Appeal Decision

Decision date: 24th August 2022

Appeal Ref: APP/R5510/D/22/3298539

13 Foxdell, Northwood HA6 2BU

FRONT ELEVATION

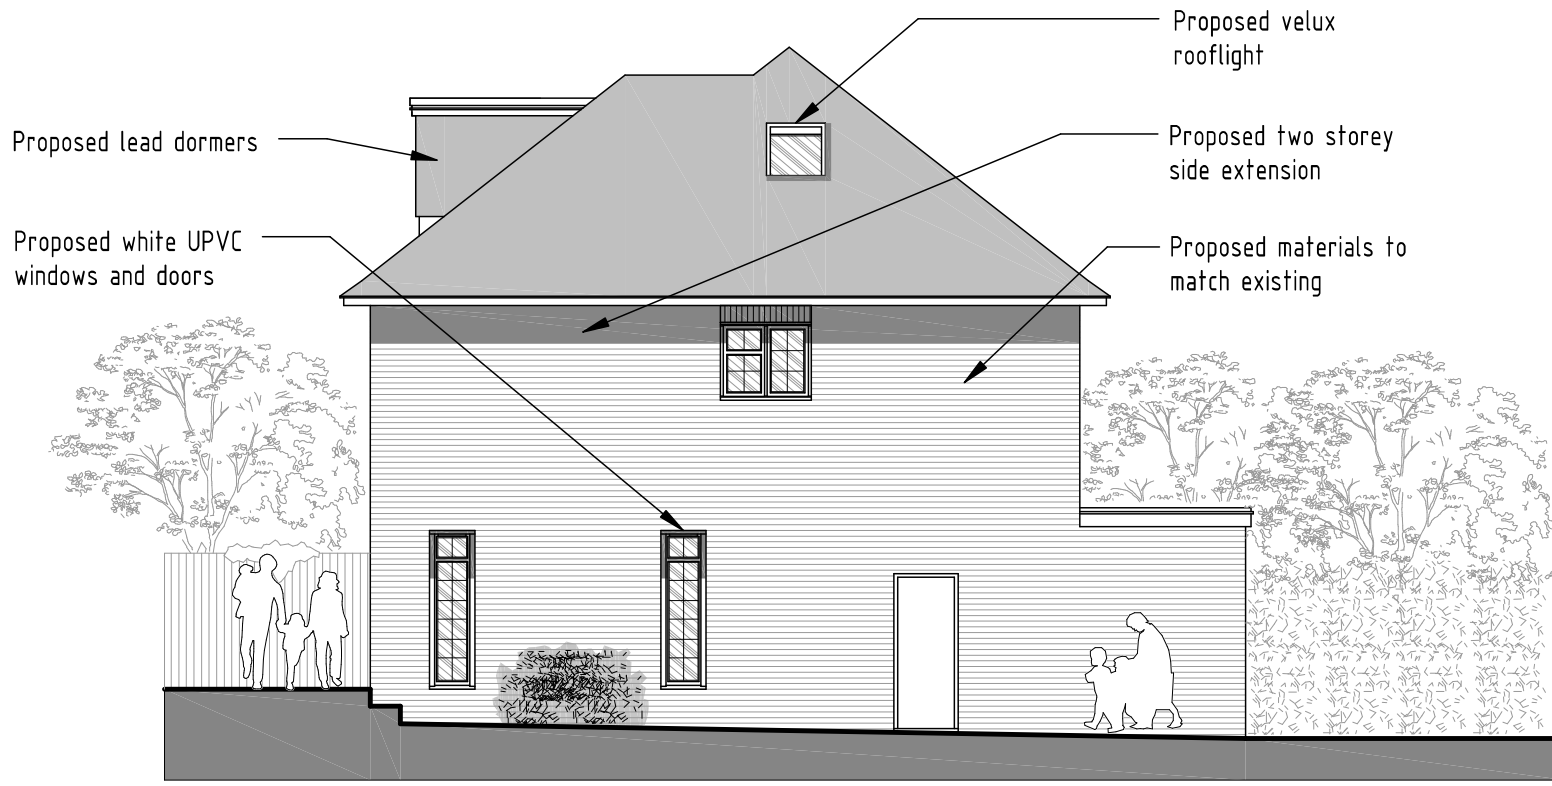
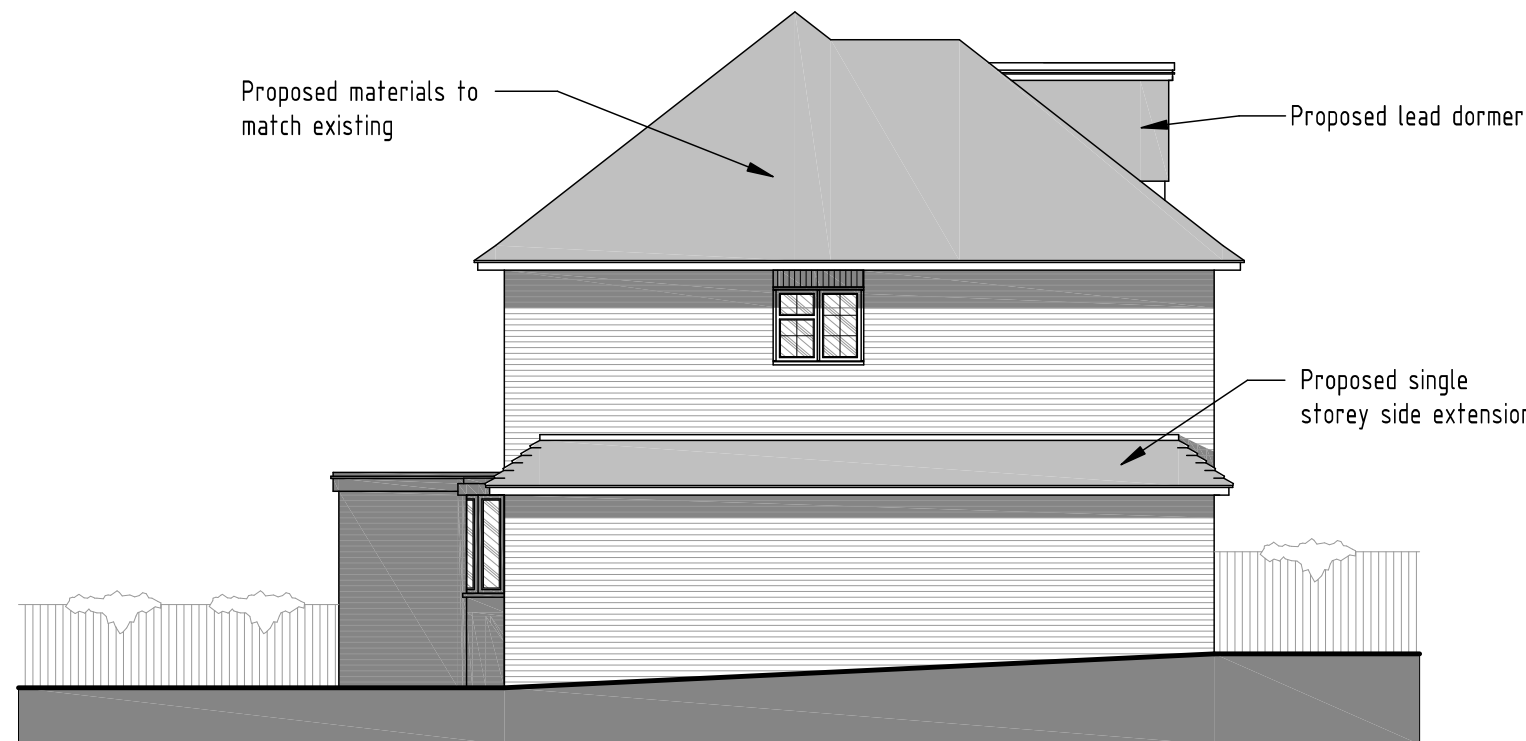
4. The proposed two-storey side extension would sit flush with the existing front elevation. However, at approximately 1.4m wide it would be very narrow. As such, it would not appear as a disproportionate addition to the side. With matching materials, I am satisfied that it would be able to harmonise with the host dwelling, in a similar way to the extension at No 5.

5. The new roof would maintain the broad appearance of the hipped roof from the front, but it would encapsulate a crown roof with a false ridge. This would be seen in angled views from the street. However, as outlined previously, there are other examples of crown roofs nearby. Even though there are differences in their sizes, they did not detract from the appearance of those houses, irrespective of frontage planting. Moreover, with it being positioned adjacent to the large gabled roof of No 11, the proposal would not appear unduly bulky.

6. Due to the narrow width and low height of the proposed ground floor side extension, it would appear subordinate to the host dwelling. The detailing of the rear patio windows spanning between the main two storey part of the dwelling and the ground floor side extension would create an awkward arrangement. However, at the ground floor to the rear I do not consider this to be so unacceptably harmful that it would warrant withholding consent. Moreover, the other alterations to the windows, including the single dormer and roof lights on the roof slope would not appear out of character in this suburban residential area.
